Application for removal or variation of a condition following grant of planning permission.

Development: Erection of a first-floor front/side extension, two-storey rear extension, Raising the ridge of the main roof, installation of roof lights and erection of front porch.

Reference number: 15480/APP/2023/1687 Date of decision (DD/MM/YYYY): 22/08/2024 (date must be pre-application submission)

## Proposed change:

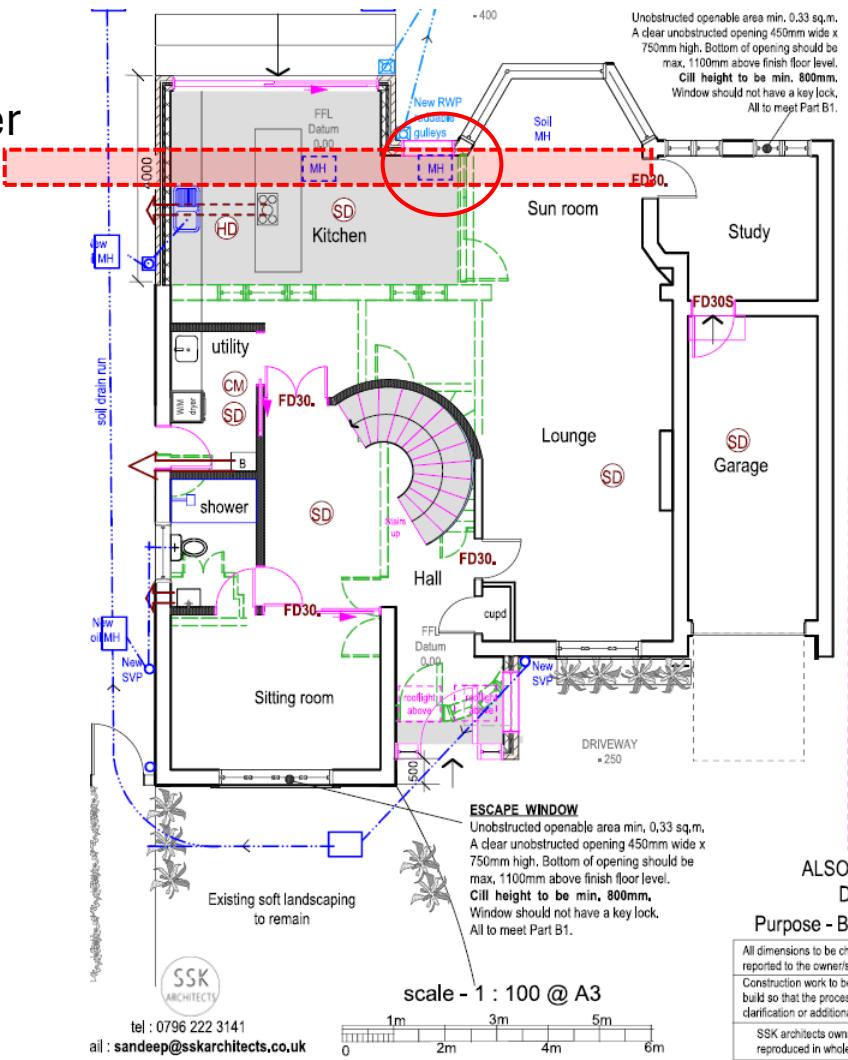
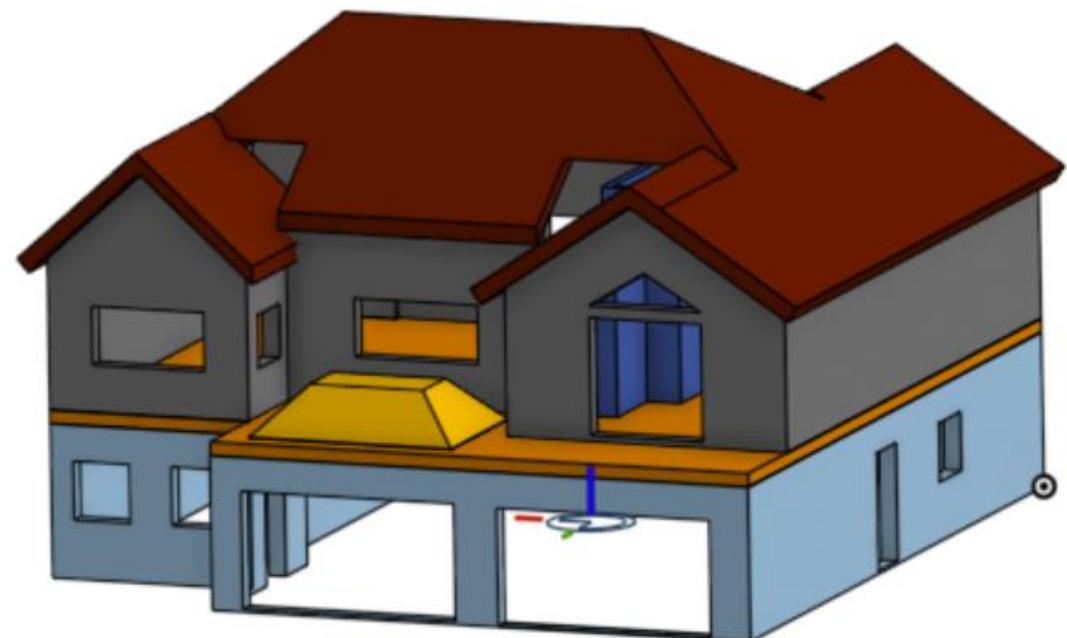
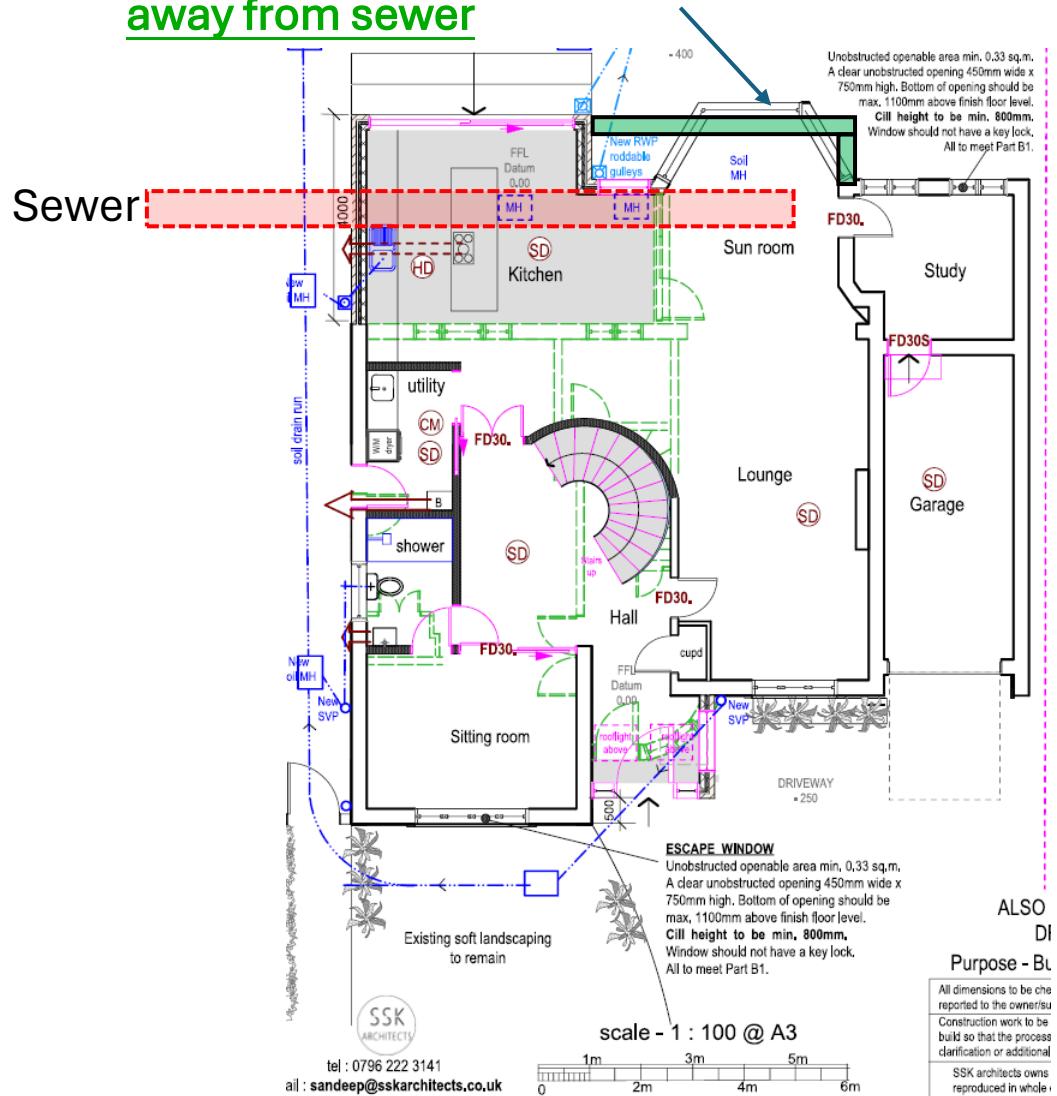
The existing plans require a foundation to be placed where the sewer is located. Furthermore, the builder informed us that it would be very difficult to seal the existing conservatory onto the building wall most likely causing future problems.

Required foundation will interfere with sewer

We would like to request that the foundation and conservatory wall can be placed onto the same line as the proposed rear extension (see attached drawing at end of form) so that foundations will not interfere with the sewer and to make sealing of the conservatory onto the remainder of the building more reliable.

Move outside wall and foundations away from sewer
